**Developments Affecting Trunk Roads and Special Roads**  
**Highways England Planning Response (HEPR 16-01)**  
**Formal Recommendation to an Application for Planning Permission**

Council's Reference: 2016/92298

Referring to the planning application referenced above, dated 27 November 2017, planning application for redevelopment for B1(C) B2 and B8 uses at Former North Bierley Waste Water Treatment Works BD12 7ET, notice is hereby given that Highways England's formal recommendation is that we:

ILLUSTRATIVE MASTER PLAN

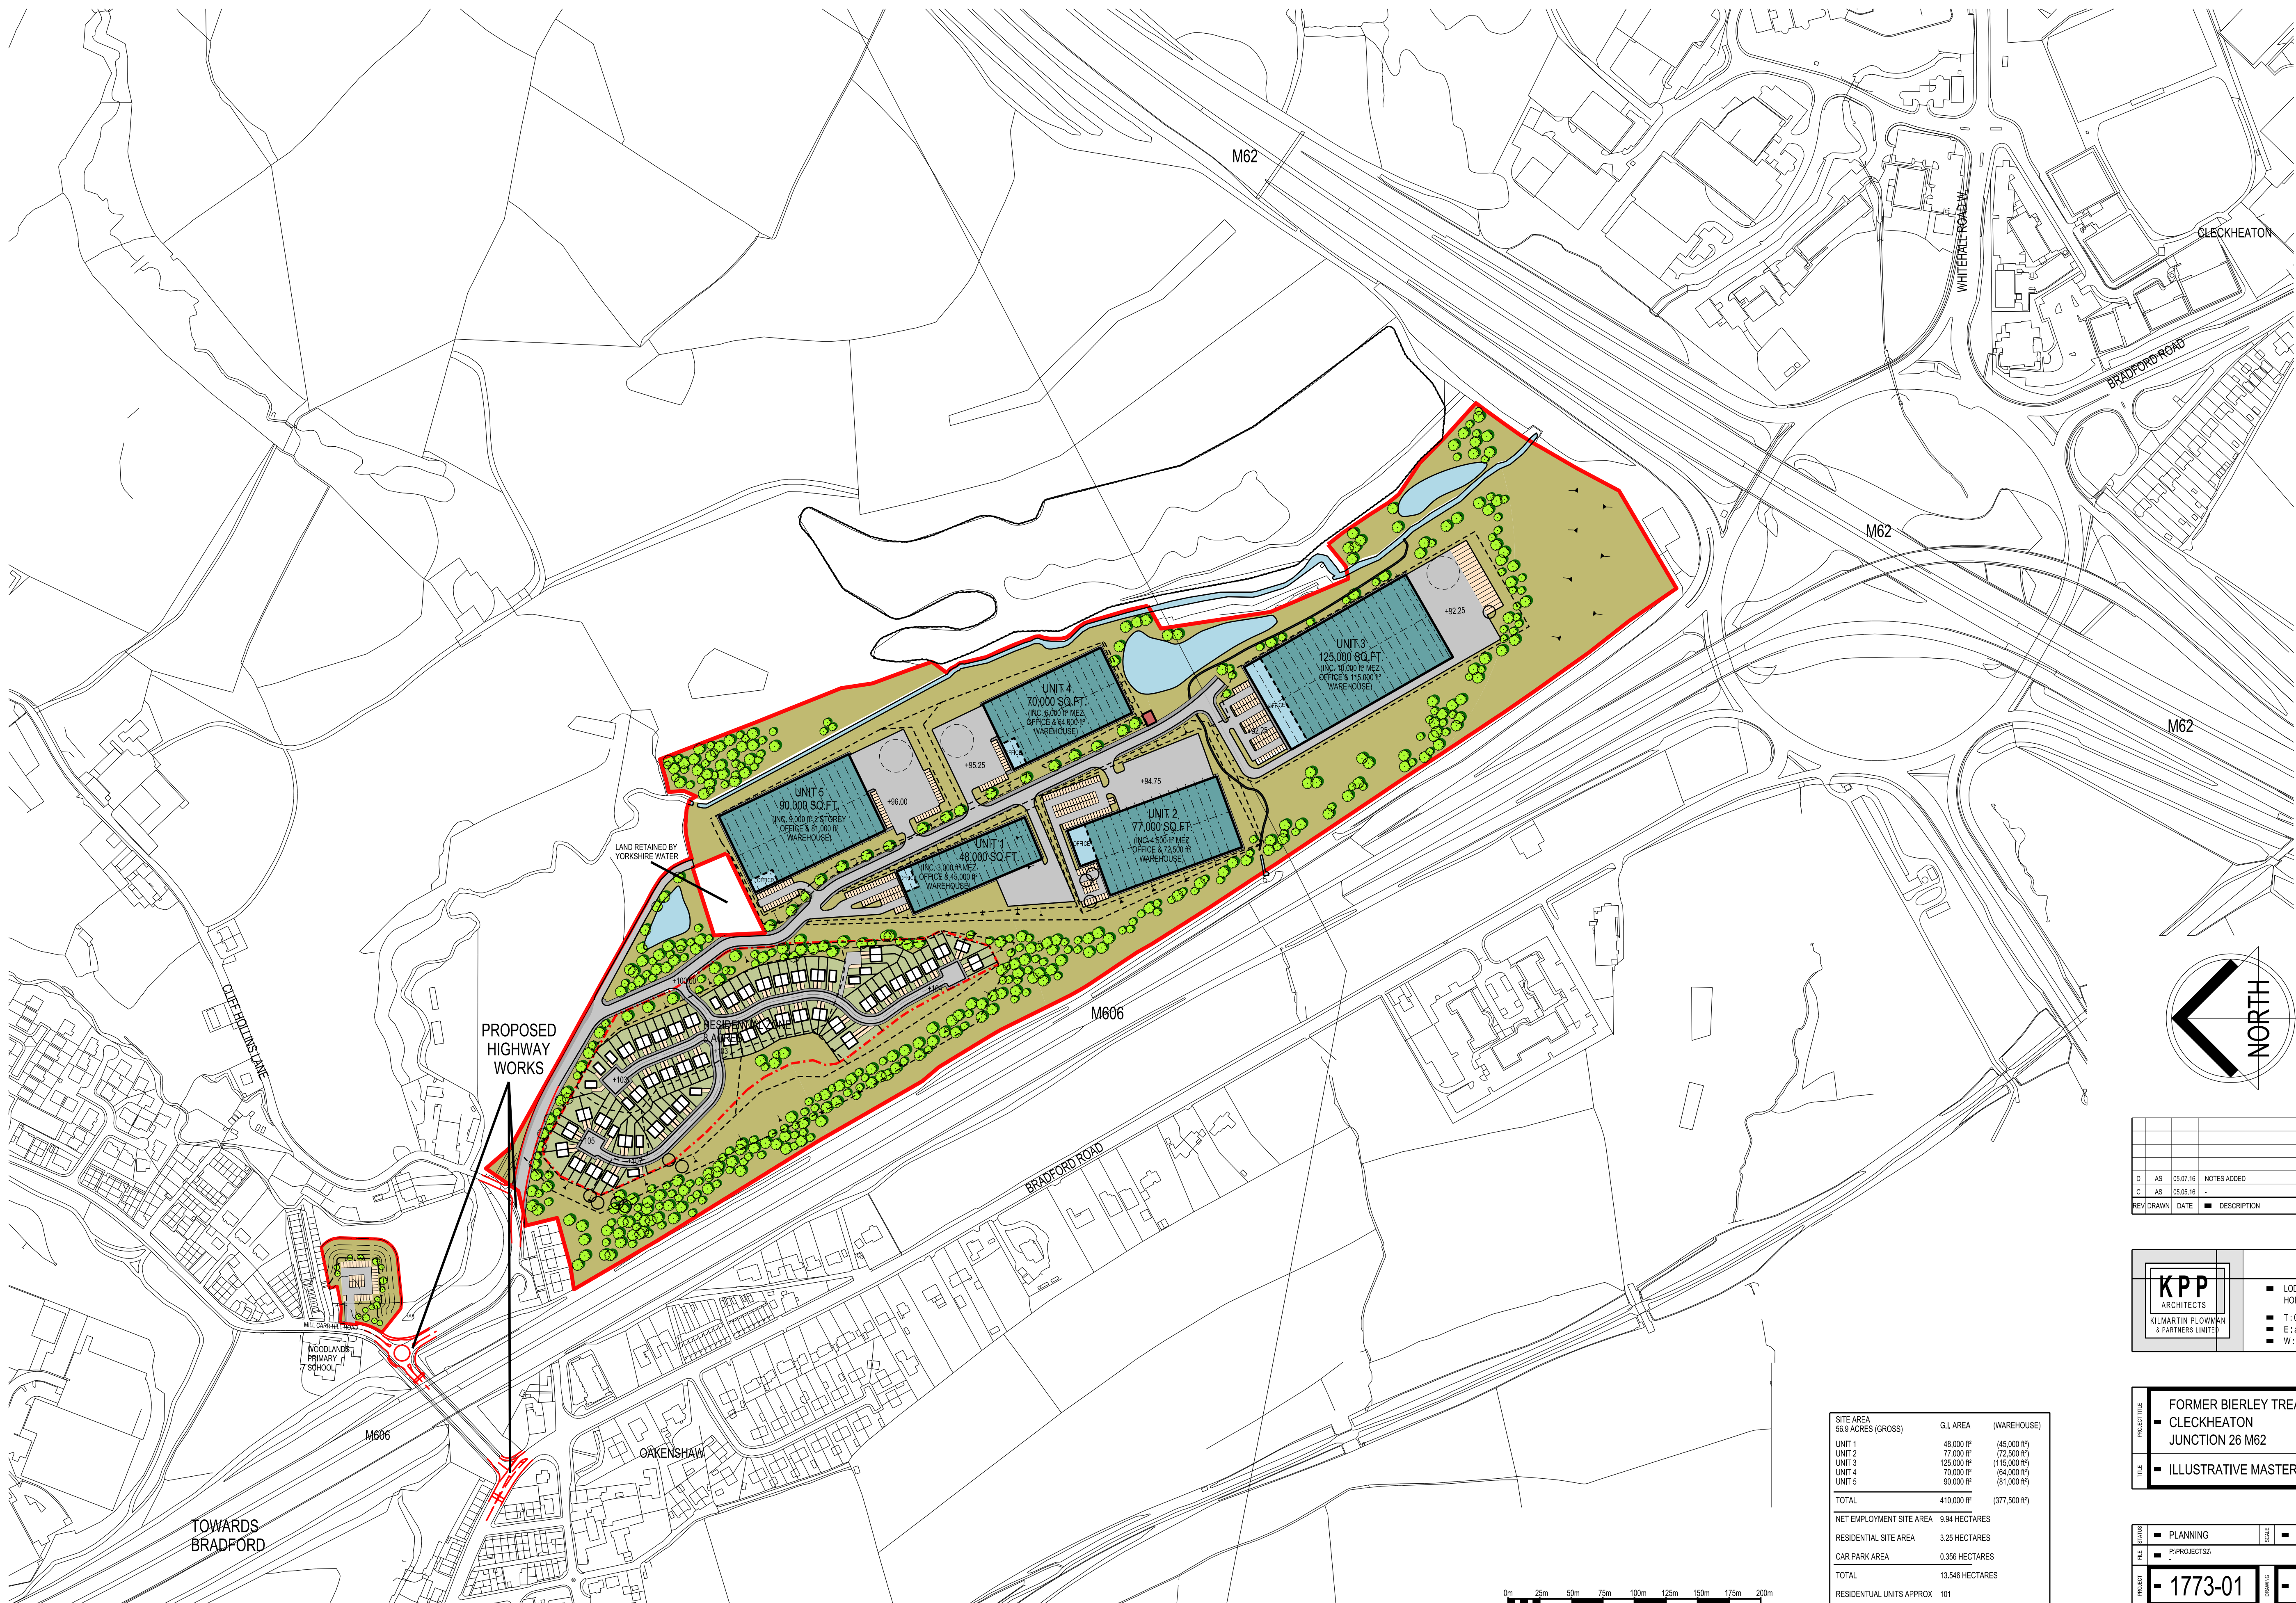
Highways England’s response to planning application 2016/92298 set out below is made on the understanding that the consent will require the development to be delivered in accordance with the KPP Parameters Plan 1773-207-G, specifically that no development shall be permitted within the area of land between the M606 and M62 slip-roads shown pink on the KPP Illustrative Masterplan 1773-01-206-G.
